**Sydney Metro Crows Nest Over Station Development (SSD-9579)
Response to Submissions**

Attachment A

SITE C

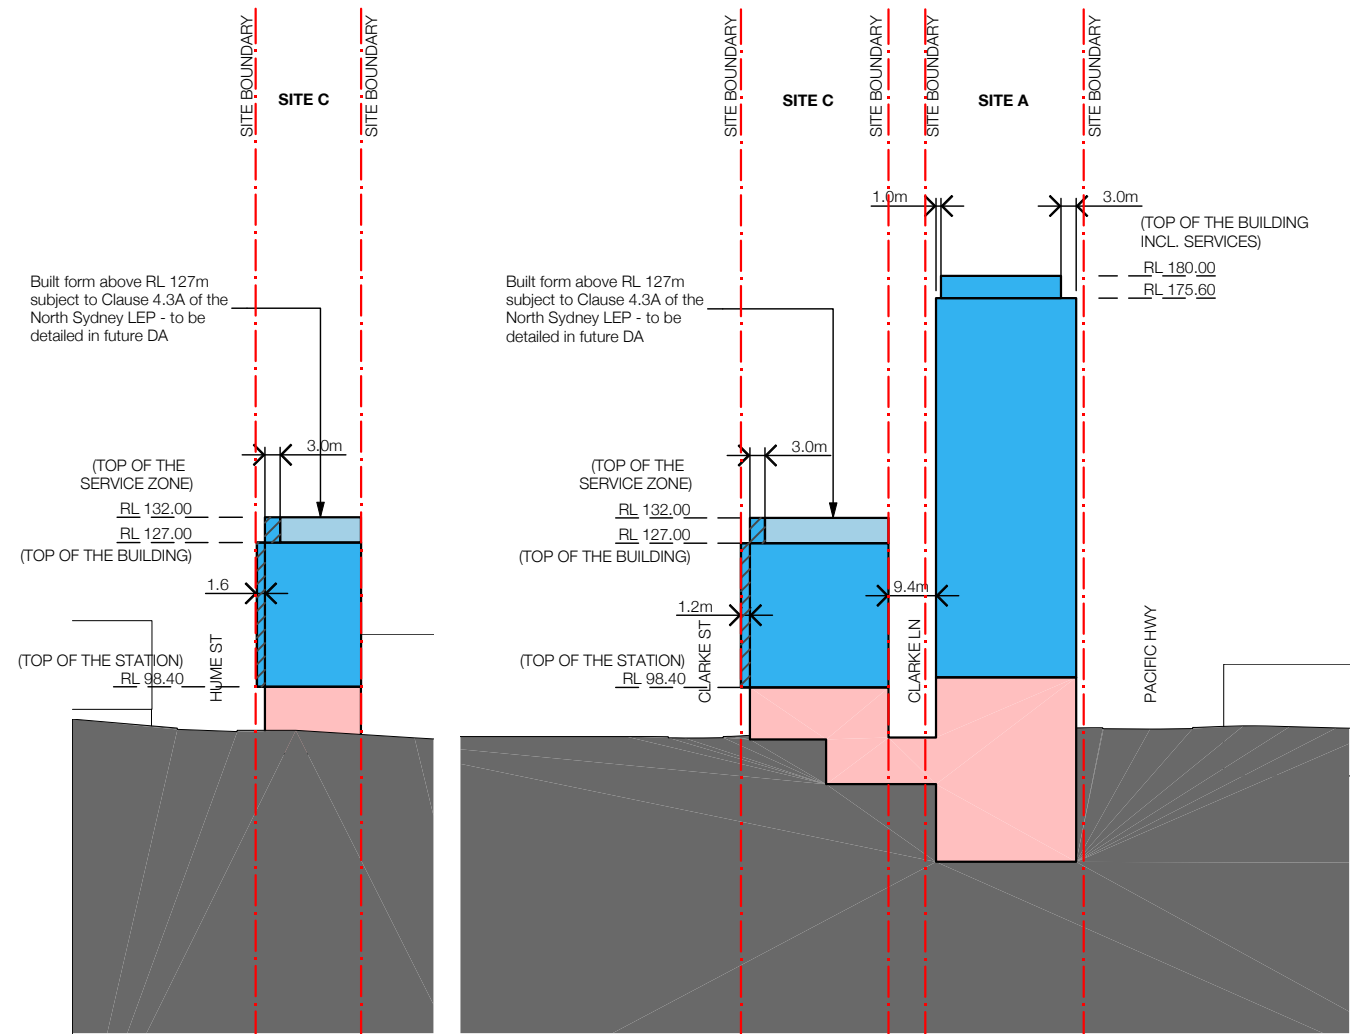
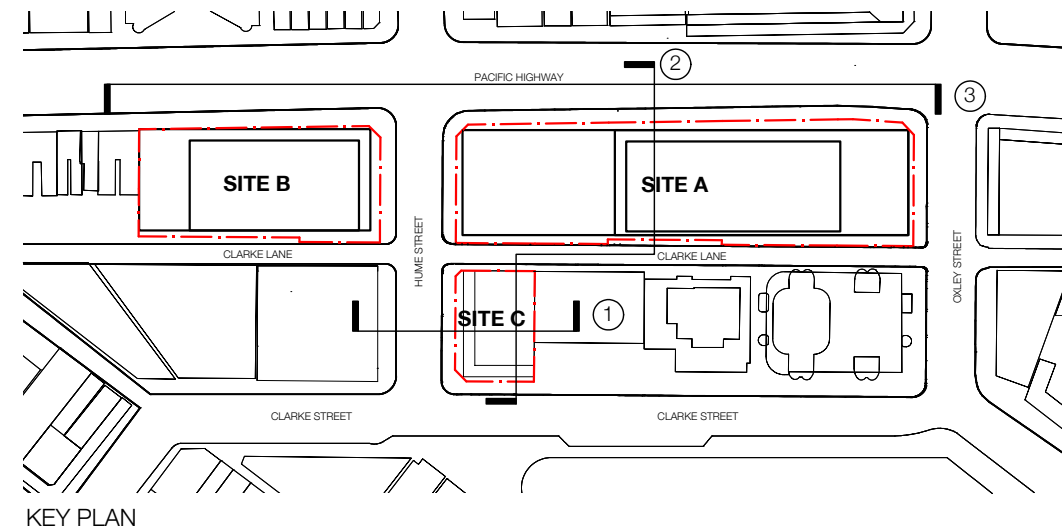
- drawing number, revision, title and date, scale
 - the separation distance between Building A and B, and Building A and C
 - a key/plan indicating where the sections have been taken.

2 CROSS SECTION-SITE A & C
1:1500

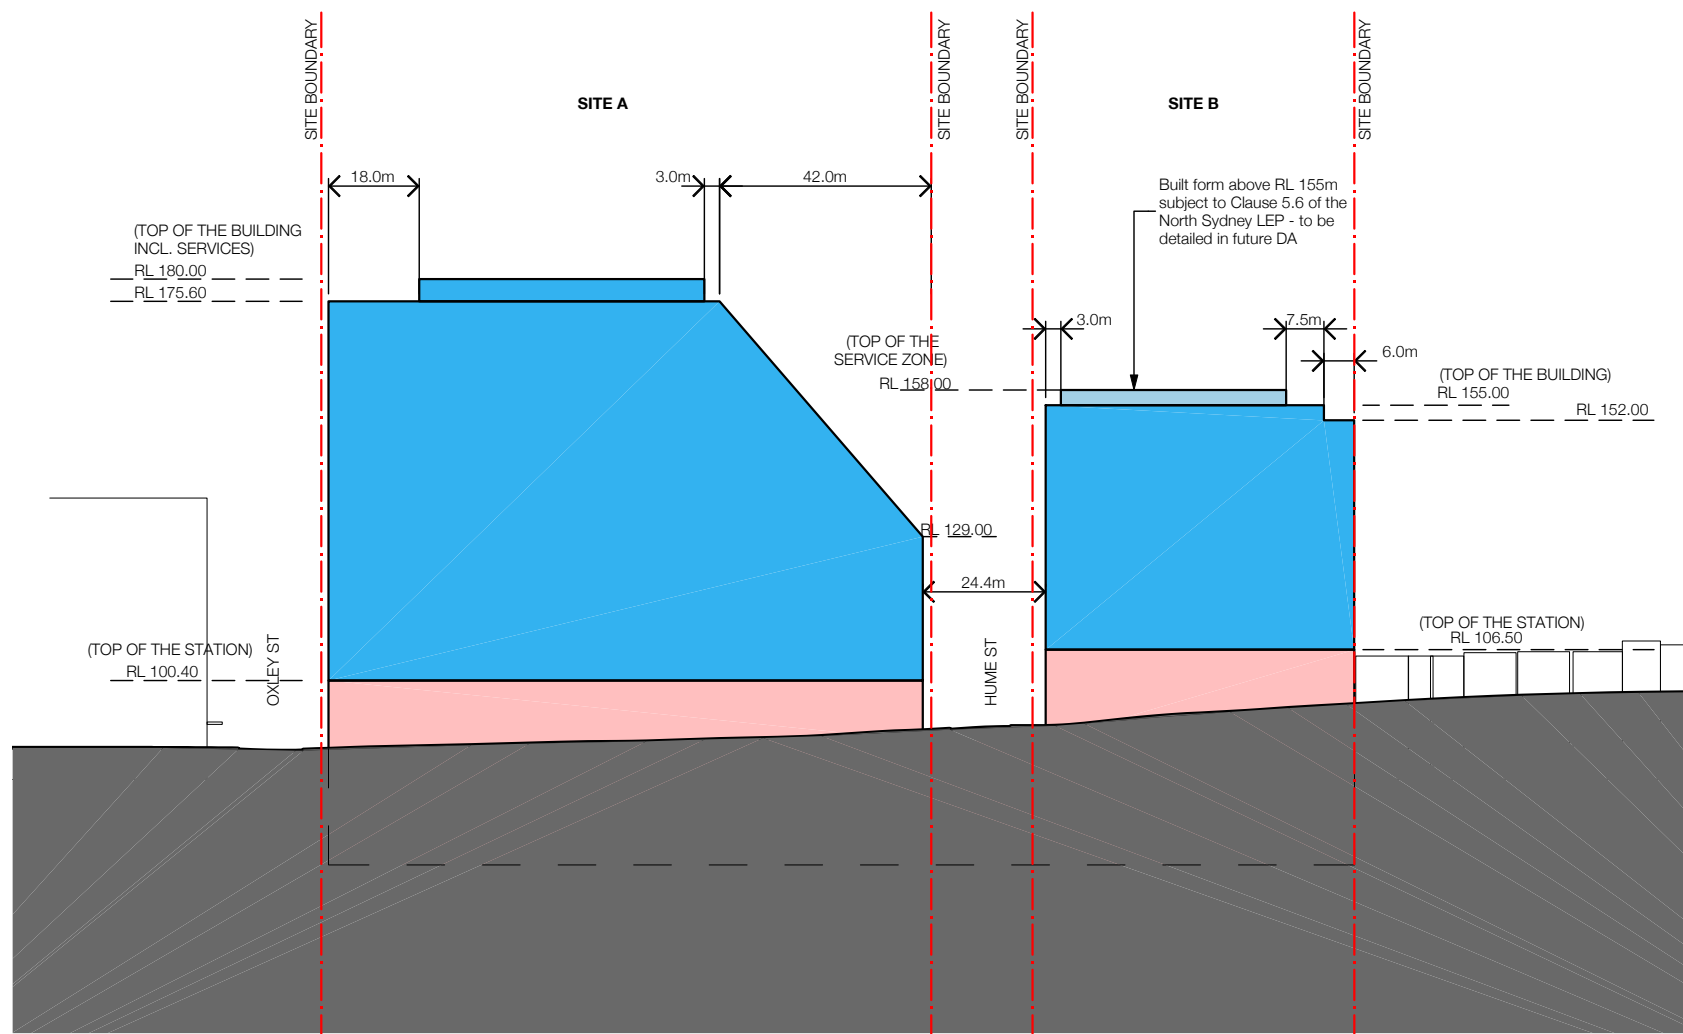
- c. Review and provide further justification for the proposed exceedance of the height of building standard and rooftop servicing zone for of Site B with consideration of:

- consolidation of plant and building services to accommodate plants and other services within the height limit
 - application of clause 5.6 of the North Sydney LEP 2013.
